Rezoning Transportation Analysis

Petition Number: 2023-040

Date	Description
7-27-23	First Review (PDM)

SHEET NUMBER  
**RZ-01**

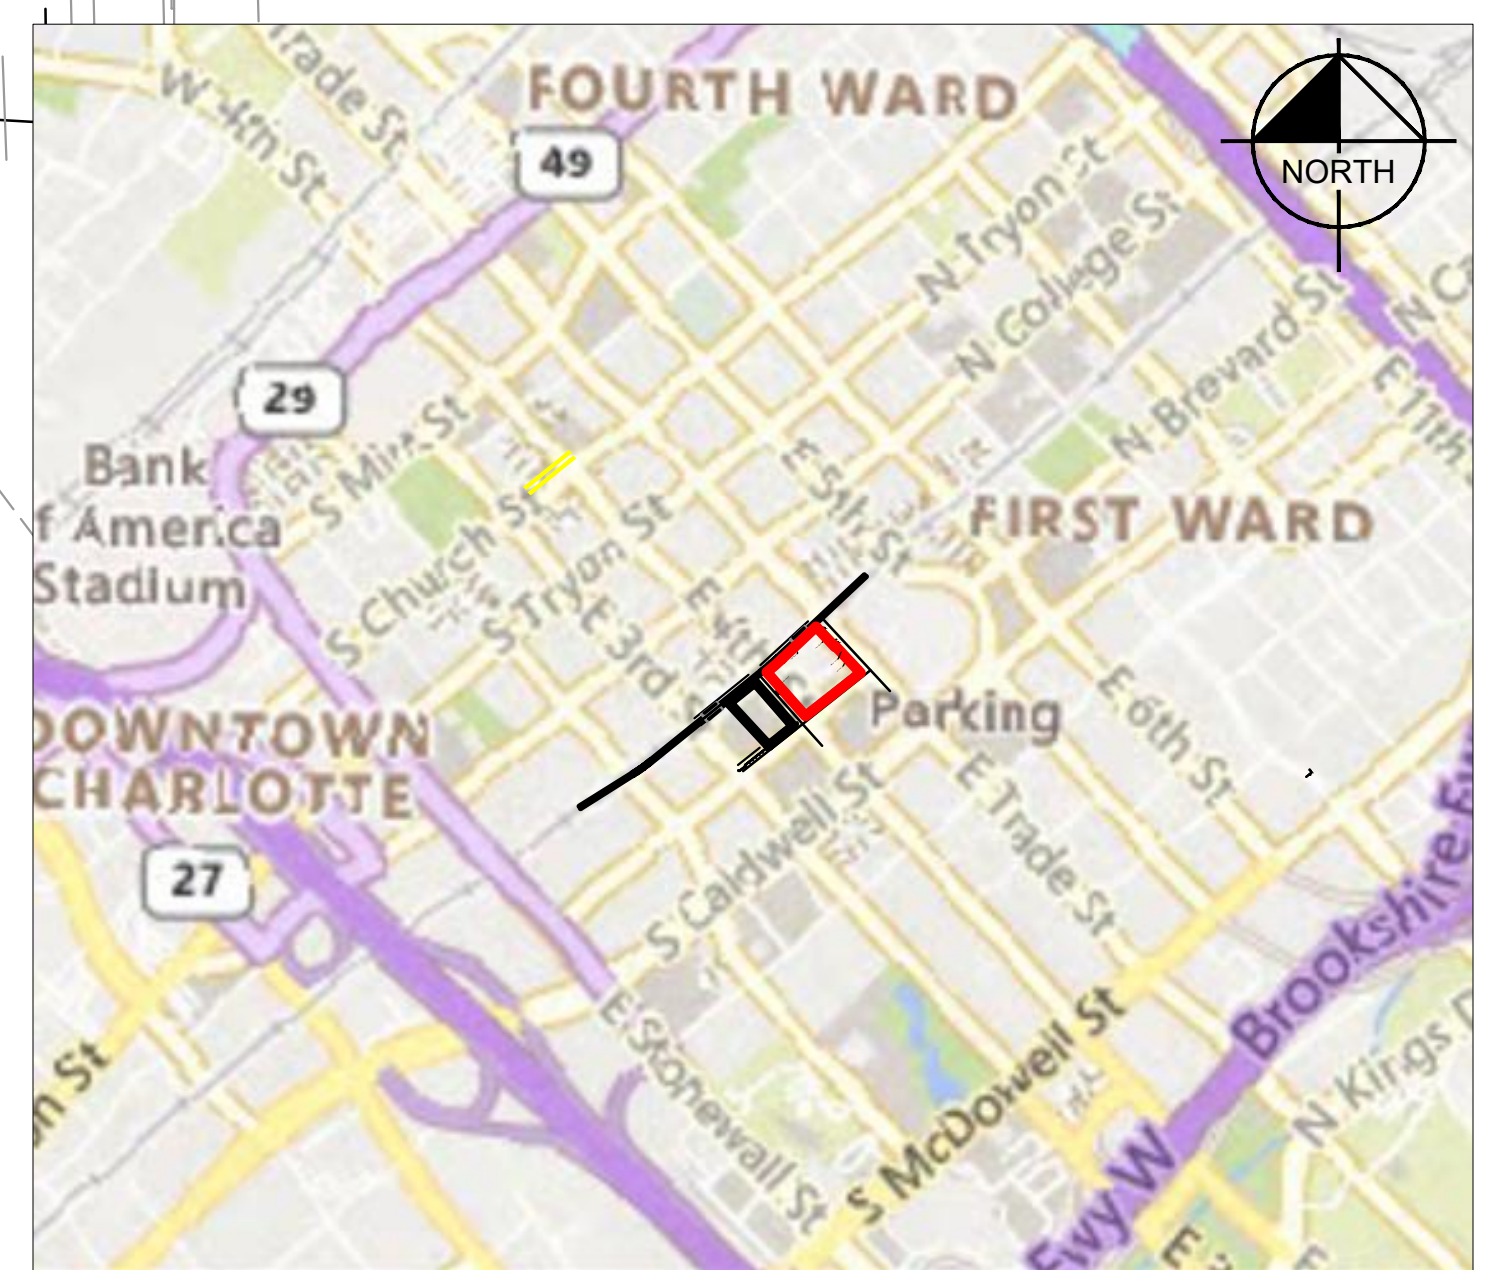
Label and dimension the curb and gutter from the centerline for each road on the site plan.

- Revise site plan and conditional note(s) to commit to dedicate a minimum of 40 feet of right-of-way from the road centerlines of Trade Street, Brevard Street, and 4th Street if it does not exist today. The site plan shall label and dimension the right-of-way from the road centerline.
- Revise site plan and conditional note(s) to commit to construct bicycle facilities by installing a multi-use path on Trade Street, Brevard Street, and 4th Street to meet the Council-adopted Charlotte BIKES Policy. Multi-use paths maintained by the City shall meet ADA/PROWAG requirements.

- Revise site plan and conditional note(s) to commit to provide the streetscape for Uptown Signature Streets on Trade Street and Brevard Street and the streetscape for Uptown Primary Streets on 4th Street.

- Revise site plan and conditional notes to provide a 12ft rail trail along the Blue Line and provide a connection to the Rail Trail to the site that accounts for bicycle traffic within the design.
